Application: SSI 7485

I write regarding the proposed modification to M4-M5 Link, Mod 2 The Crescent overpass and changes to pedestrian infrastructure in North Annandale, Rozelle and Rozelle Bay Foreshore area.

Figure 4-4 Elevation: Indicative view of The Crescent overpass

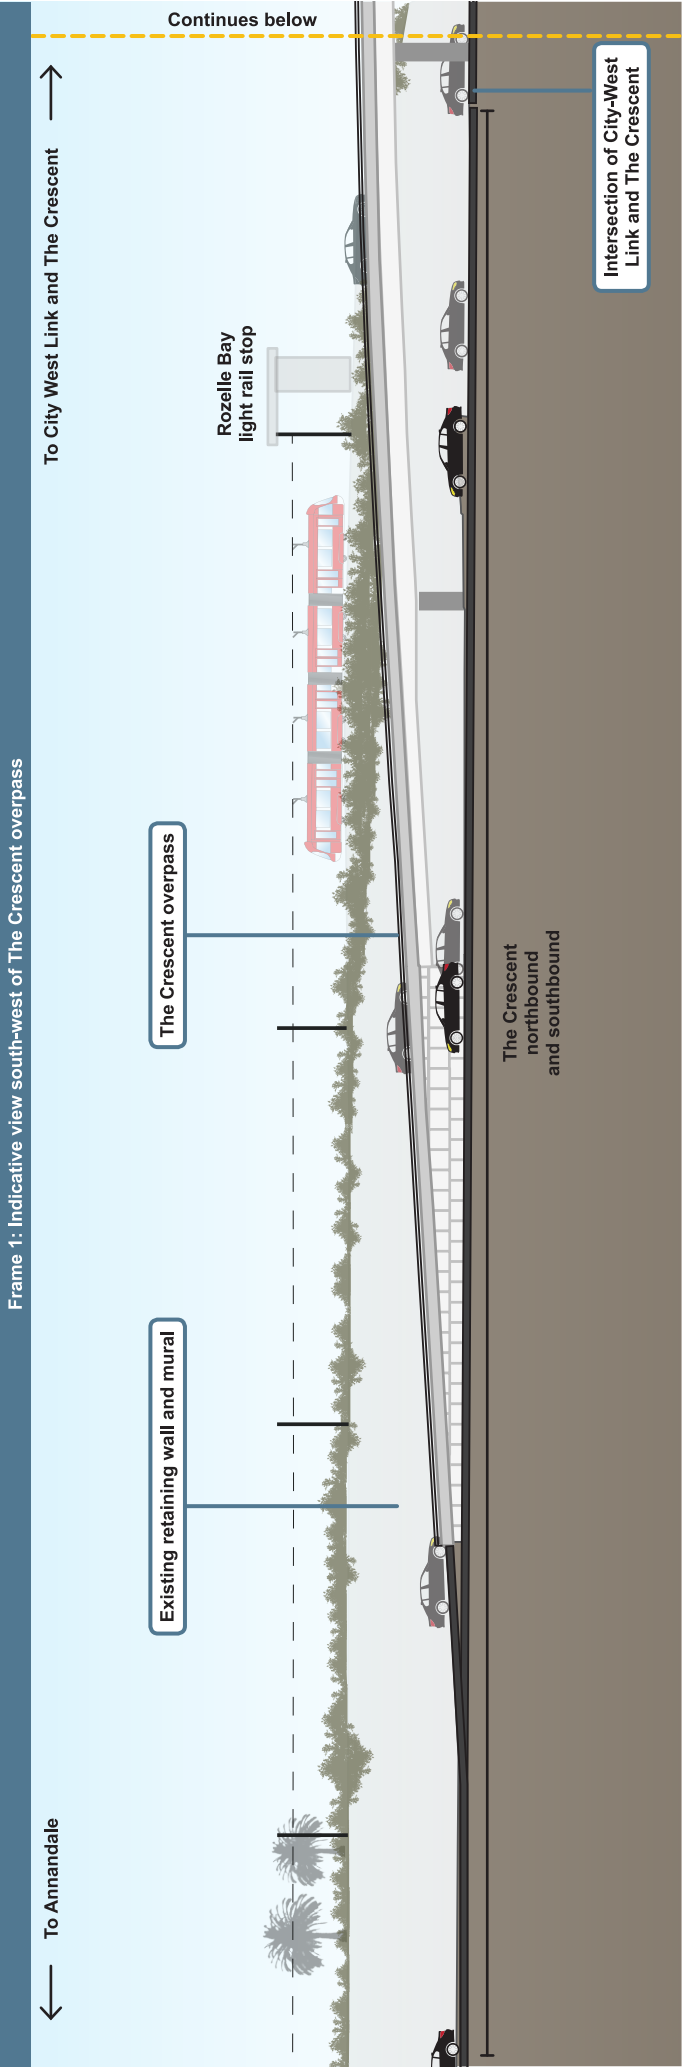
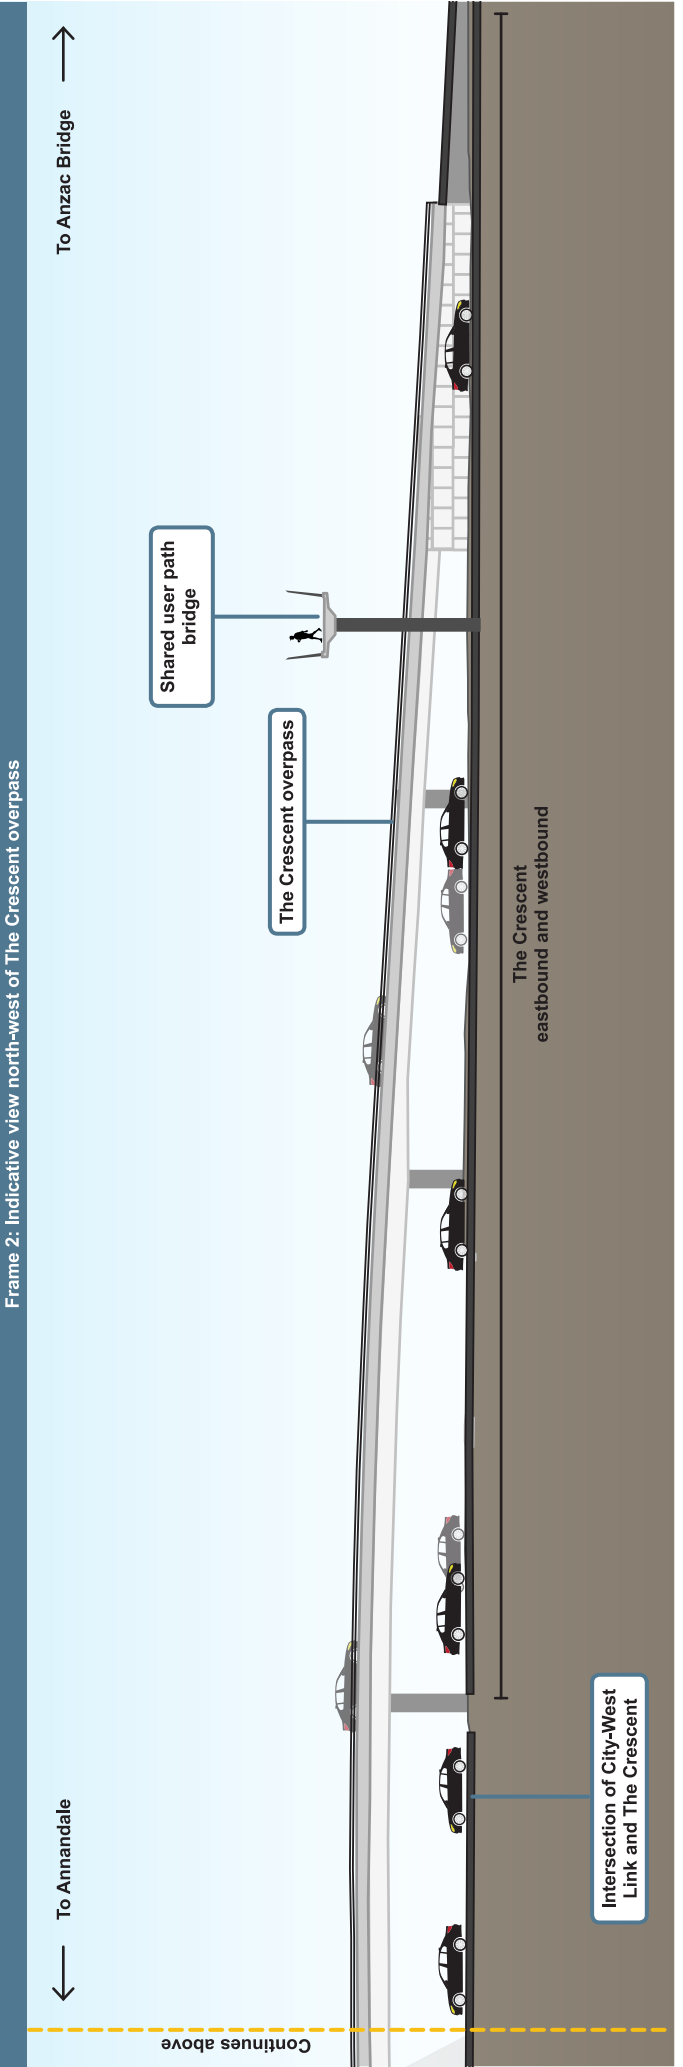
We object to the overpass as put forward in the modification & the relocation of the GreenLink

I request RMS work with the community to explore alternate design options to the proposed new car overpass design and the changed pedestrian and cyclist links. I am seeking the reinstatement of the safe, direct access from the approved EIS GreenLink to create a continuous green open space connection from the Rozelle Rail yards and Annandale to the foreshore. The GreenLink was more than just a walk way - it put people central to the design, maximising safety, and providing much needed accessible open space for the community now and into the future Bays Precinct design.

- The significantly reduced safety and increased risk for pedestrians and cyclists with removed access over The Crescent to Bicentennial Park and the increased traffic along Johnson Street.
- Being required to cross five sets of pedestrian lights at The Crescent as my option to reach the foreshore from Annandale or from Rozelle Bay light rail stop.
- Removal of direct active links to the foreshore, cutting the community off from the area and the proposed revitalisation of the entire Bays Precinct, including linking the Light Rail and Bus stops to a Ferry wharf and Metro station.
- Urban and landscape design that is being built before a finalised Masterplan for the area.
- Traffic changes that limit movements around the suburb and create further congestion in the local streets of Annandale, Forest Lodge, Glebe, Lilyfield and Rozelle with no planning to deal with these.

- Reinstate the GreenLink connecting communities and green open space from Rozelle to Bicentennial Park
- Relocate and design pedestrian and cyclist connections that are continuous, safe and direct.
- Design the modification infrastructure and active links in response to the character of the suburbs, the location of the foreshore and it's potential future development.
- Provide pedestrian and cyclist paths that maximise people safety and do not force them onto busier streets, unsafe concrete plazas and caged walkways.
- Integrate active and direct connections to all active transport – including the future Metro West and Foreshore Ferry Wharf
